PLANNING CONSULTATION RESPONSE

Application No	2026/0420
Proposal	Erection of 10no. 2 and 3 storey detached dwellings
Address	Land west of Sheffield Road, Birdwell, Barnsley
Date of Consultation Reply	05/08/2026
Consultee	Highway Drainage

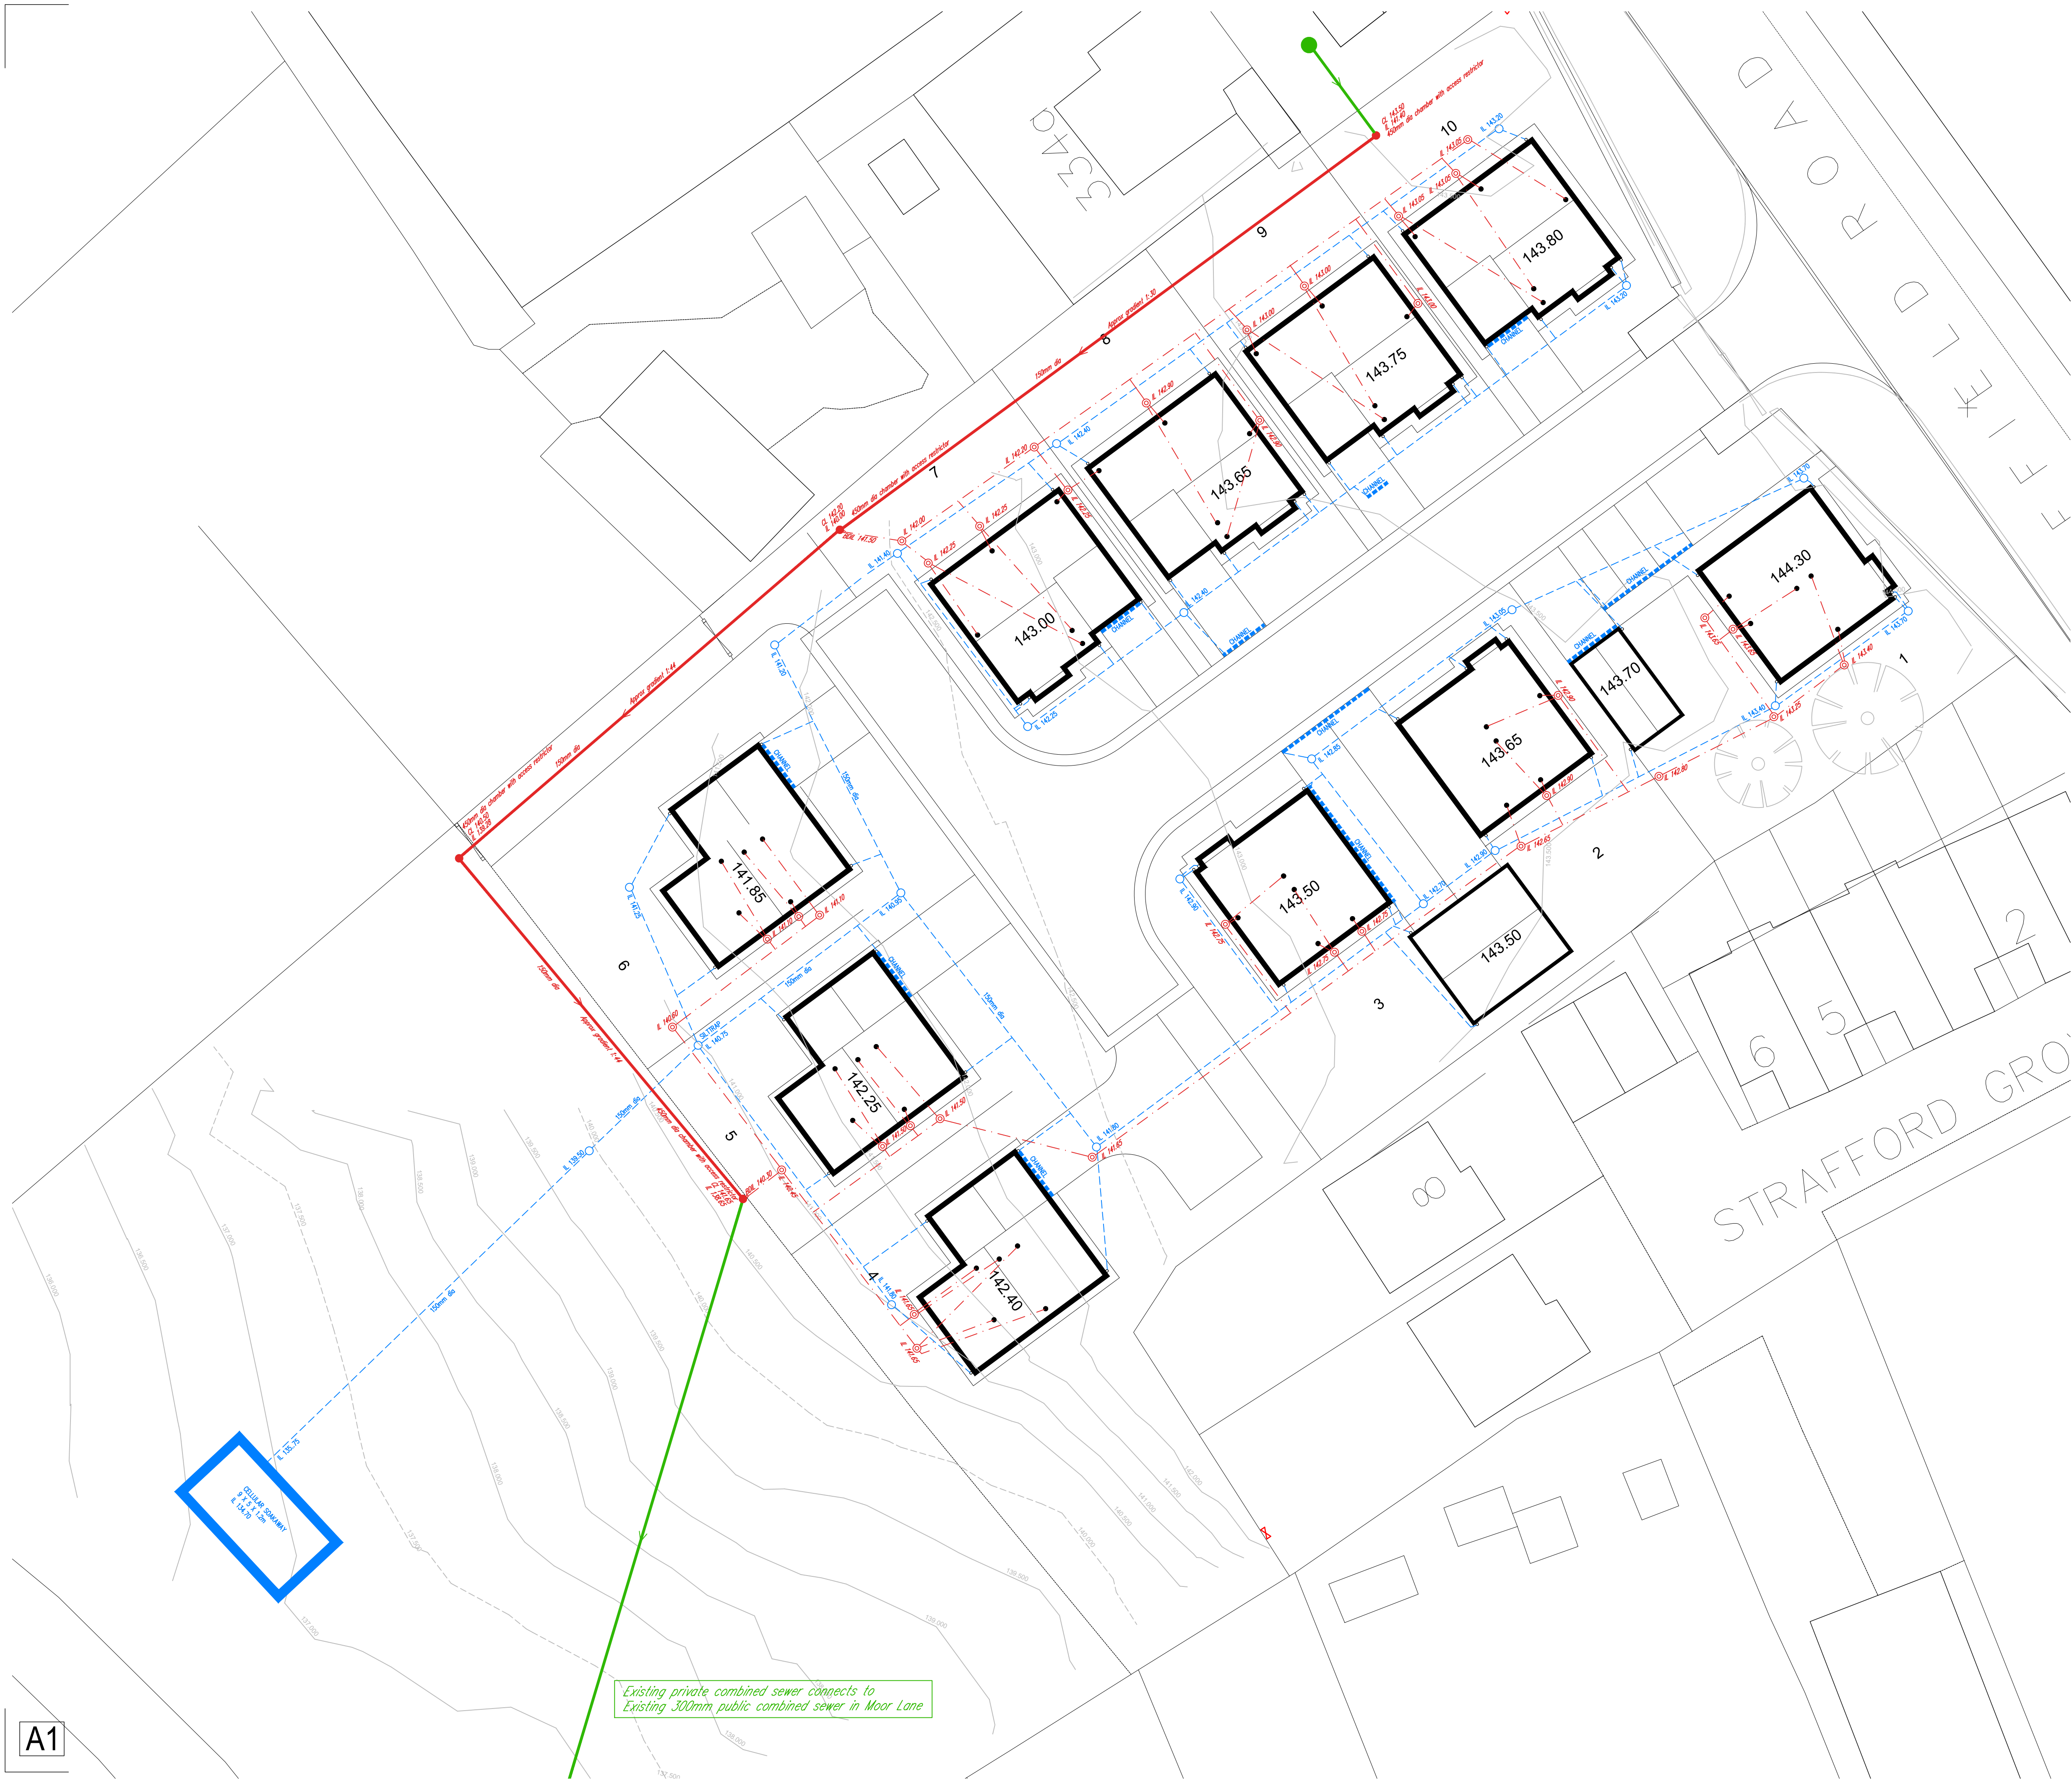
I am concerned with the location of the proposed soakaways above the motorway banking, can these be relocated within the site
